From: **Marge Schmuckal** MES@portlandmaine.gov   
Subject: 170 Woodlawn Ave - 2014-01839 - 438-C-045  
Date: August 20, 2014 at 10:40 AM  
To: hhollauer@yahoo.com

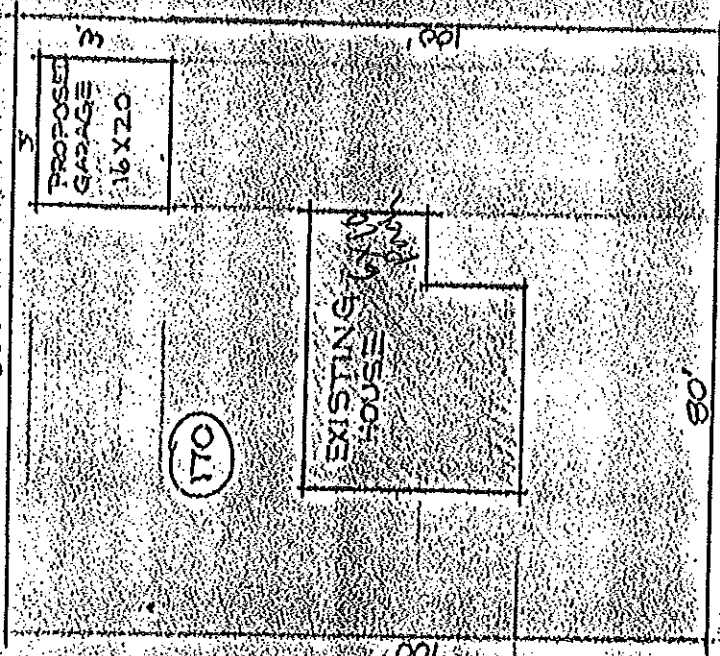
I am in receipt of your application to rebuild decks on the rear and side of your building. Our records show that there were never any permits applied for to legalize those decks. I am attaching a submission dated in 1981 that clearly shows the lack of decks in the rear. There have been no other applications since 1981 to allow those decks to be built. Therefore, it will first be necessary to legalize the rear decks before this office can approve your permit. We will need another permit showing how the decks are built (sizes of the materials use and their current spans) along with a good plot plan that shows the setbacks to the rear and side property lines.
